Date: 29 January 2025  
Your Ref: EN010125/IP No. 20050058  
Our Ref: 17996

**IP NO. 20050058 – WRITTEN REPRESENTATIONS ON BEHALF OF NET ZERO NORTH SEA STORAGE LIMITED**

**EN010125 – APPLICATION BY RWE RENEWABLES UK DOGGER BANK SOUTH (WEST) LIMITED & RWE RENEWABLES UK DOGGER BANK SOUTH (EAST) LIMITED FOR AN ORDER GRANTING DEVELOPMENT CONSENT FOR THE DOGGER BANK SOUTH OFFSHORE WIND FARMS**

- Offshore Order Limits
- ⊙ Offshore Order Limits Node Point
- Sheet Boundary

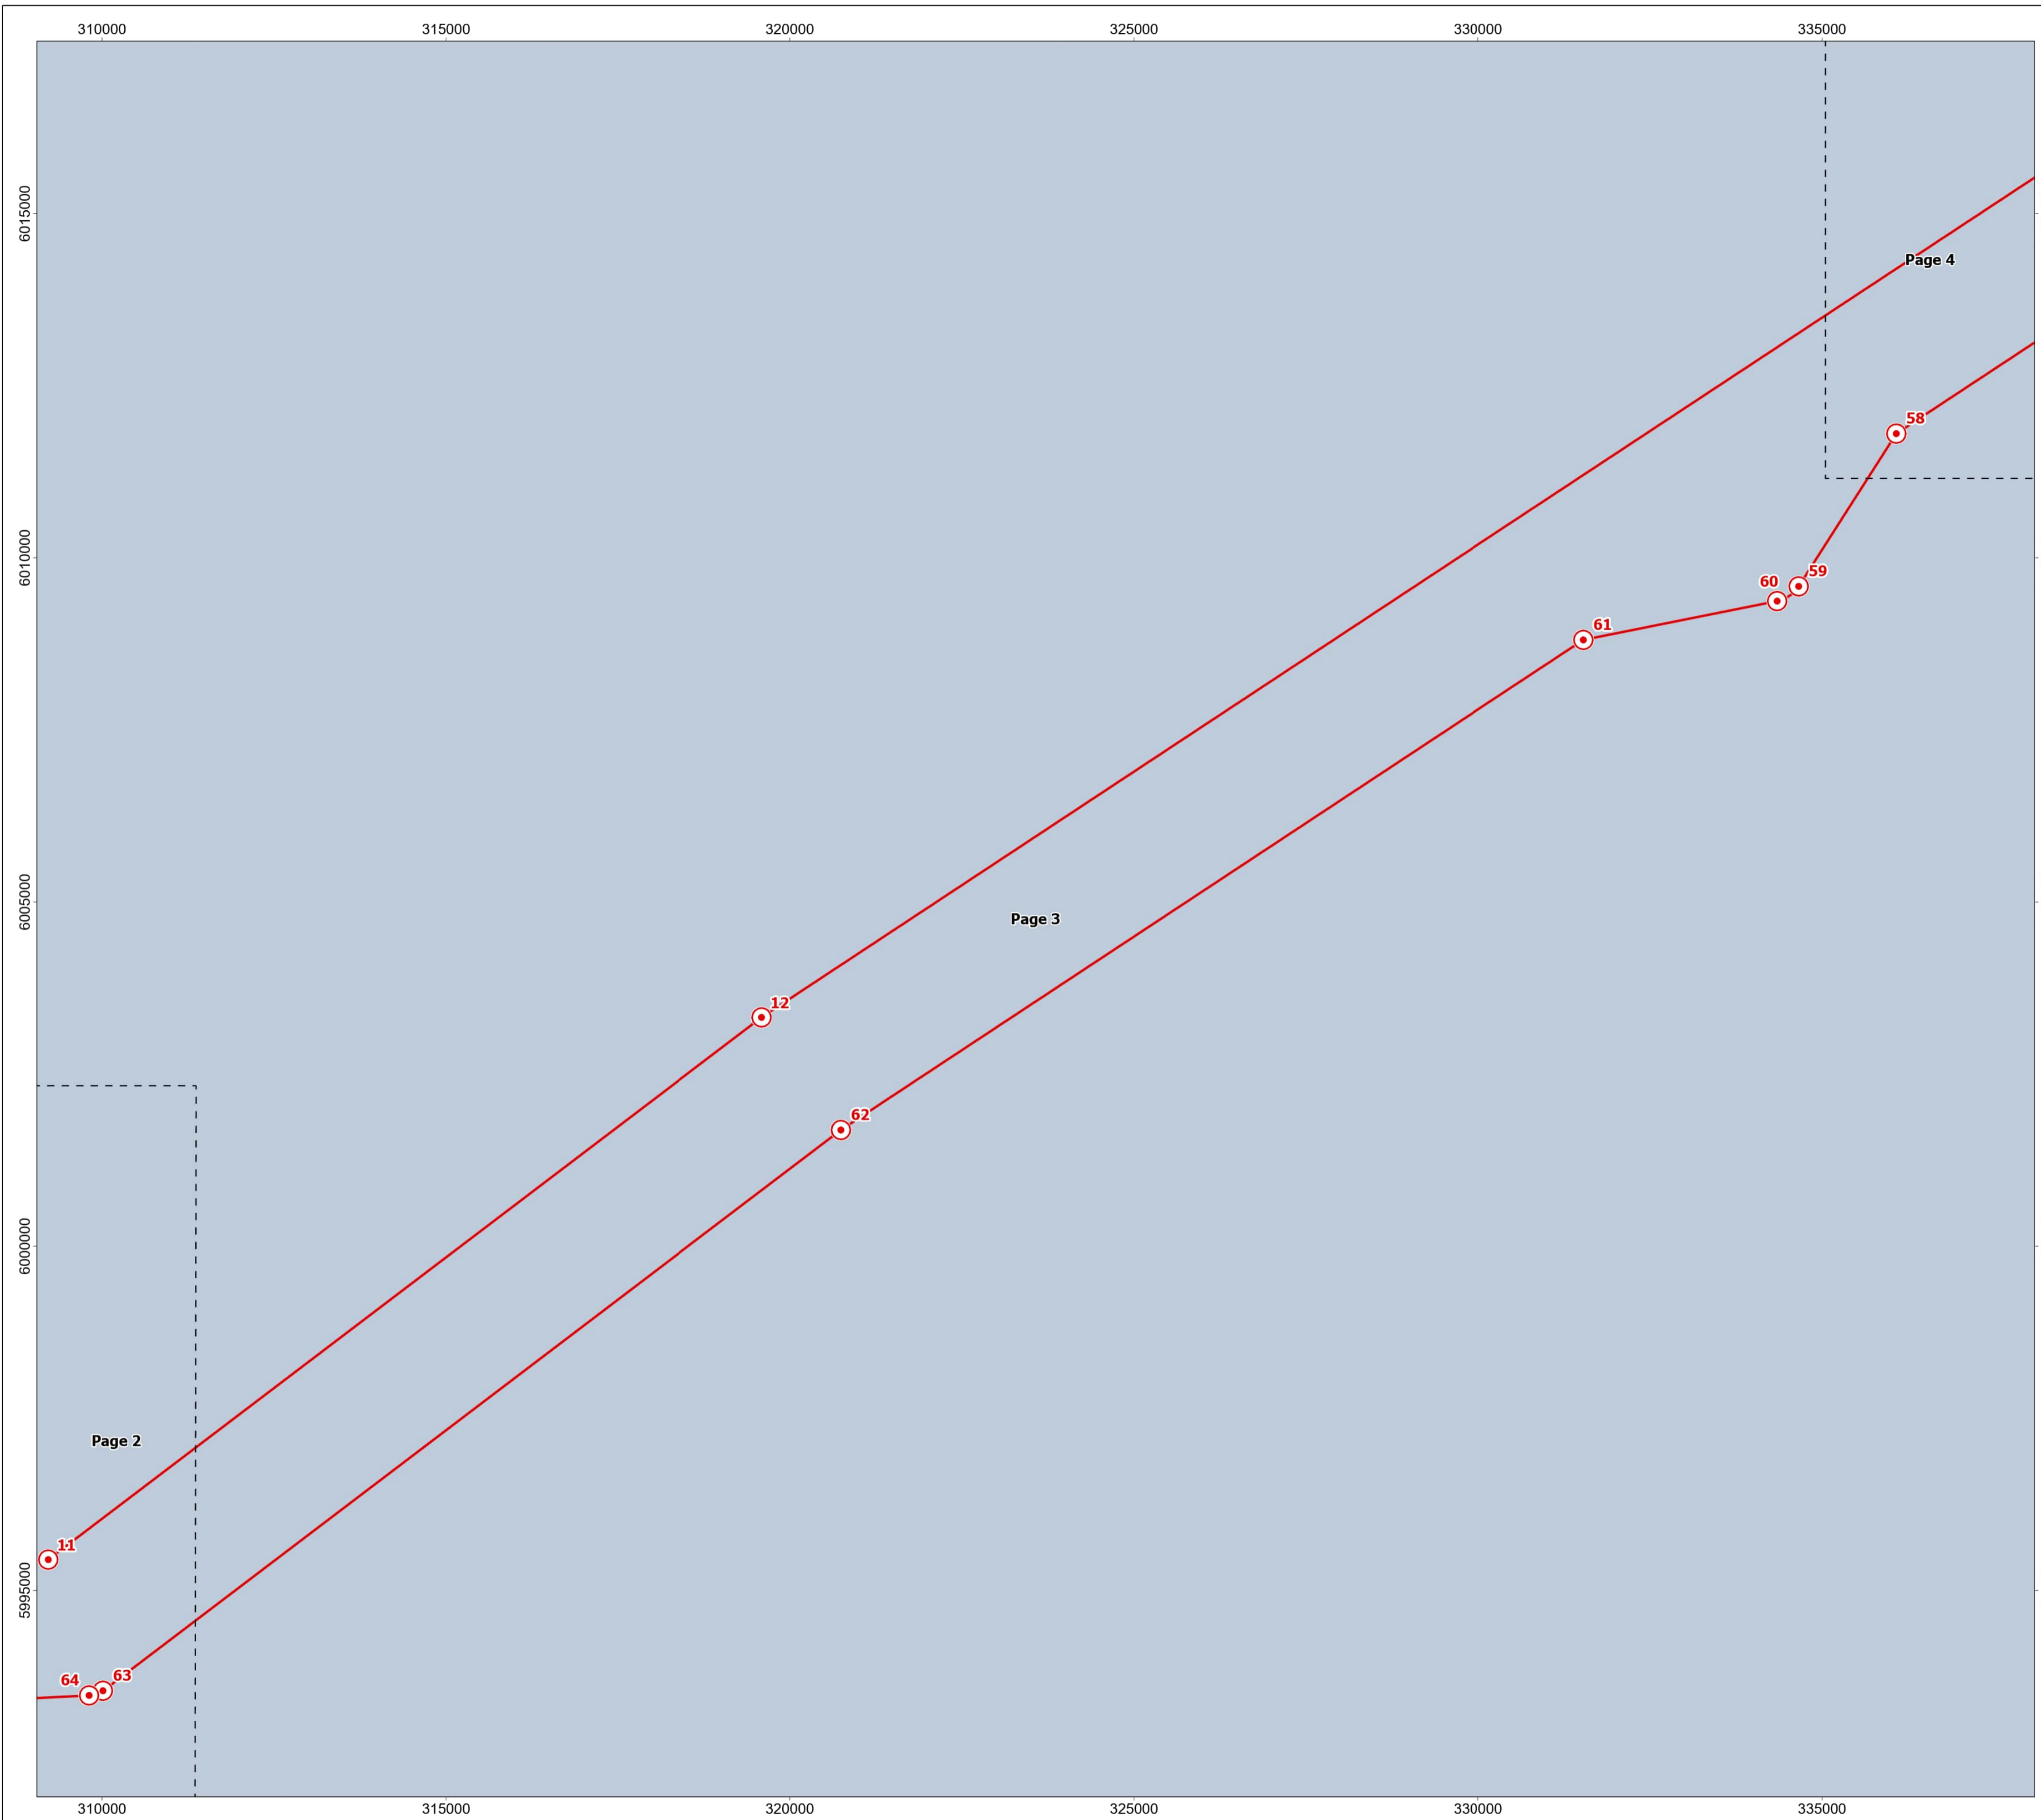
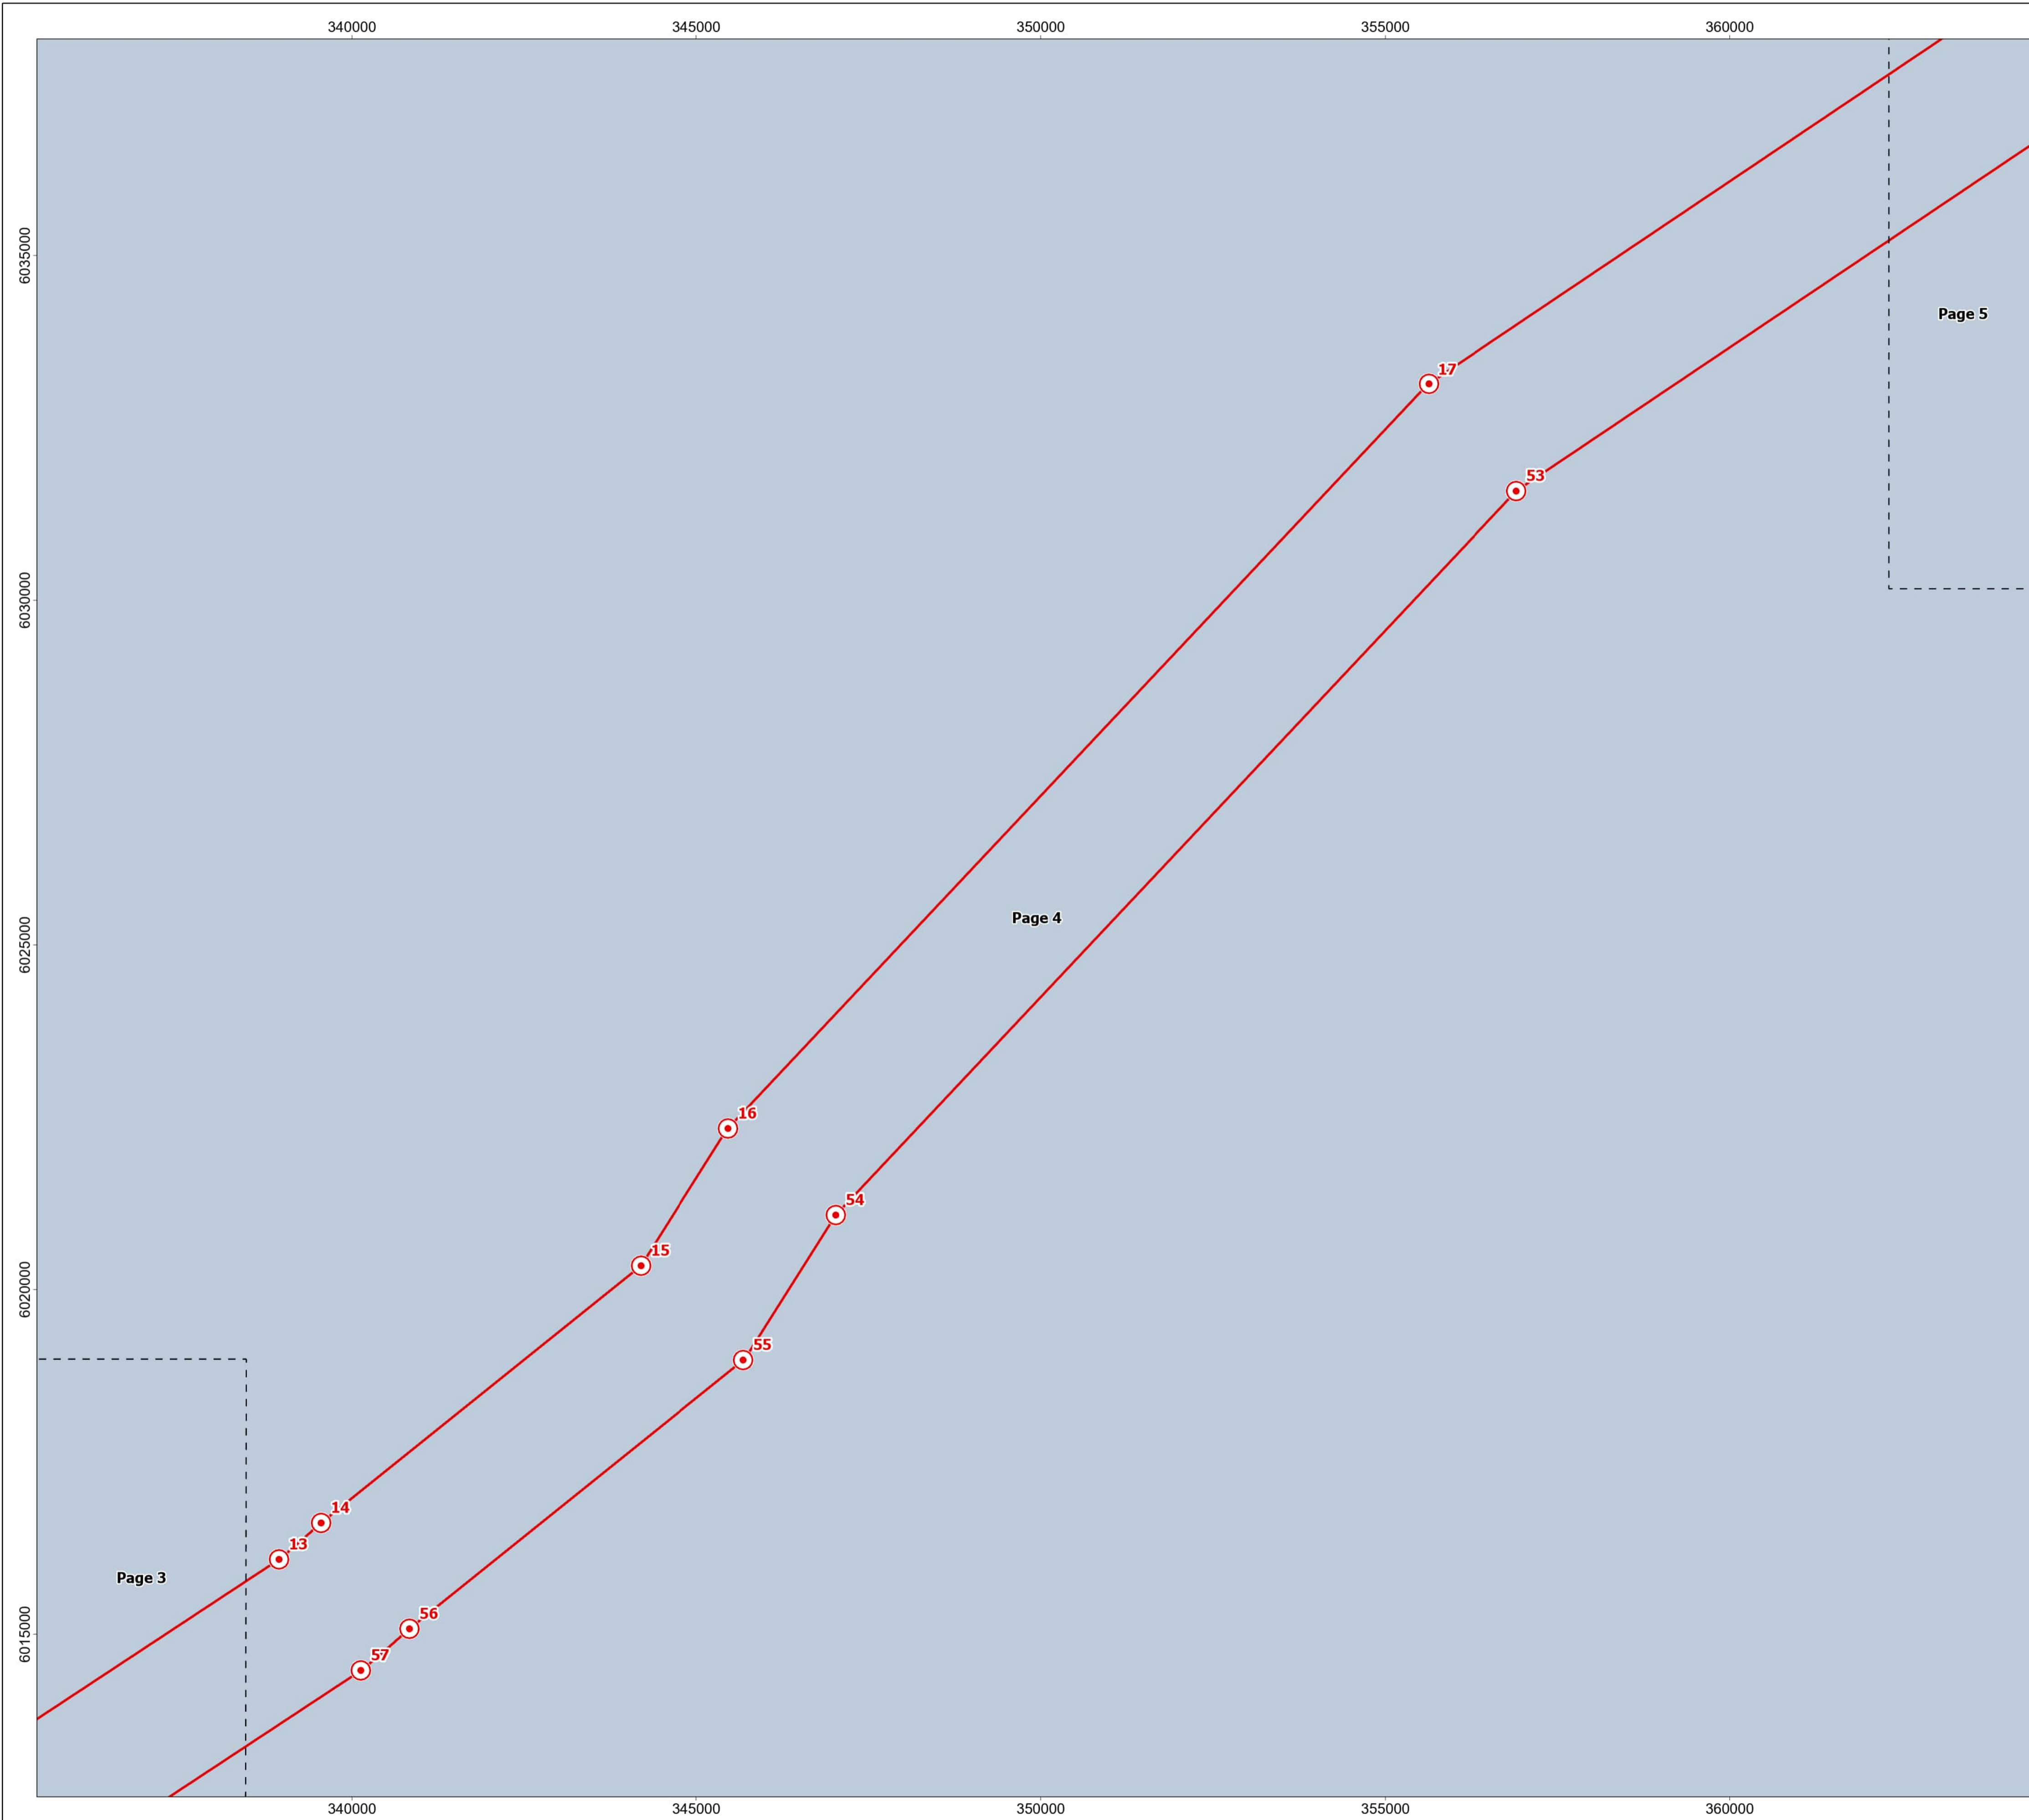
The Land and Works Plans that form part of the Application indicate that the electrical cable corridor for the Proposed Development will cross the Teesside pipeline. In addition, the southern routing of the electrical cable corridor will cross the CS025 Storage Licence area where NEP is developing a further carbon dioxide store.

Having reviewed a number of the key application documents, NSNZS is concerned as to the lack of detail within the Application on how the interactions of the electrical cable corridor with the Teesside pipeline and the CS025 carbon dioxide store will be managed and any impacts mitigated.

NZNSS needs to see further information as to the construction methods that RWE proposes to cross the Teesside pipeline and the carbon dioxide store and how construction and other impacts will be minimised and mitigated in order to ensure that it is satisfied that there will be no adverse effect on the NEP infrastructure and its operations.
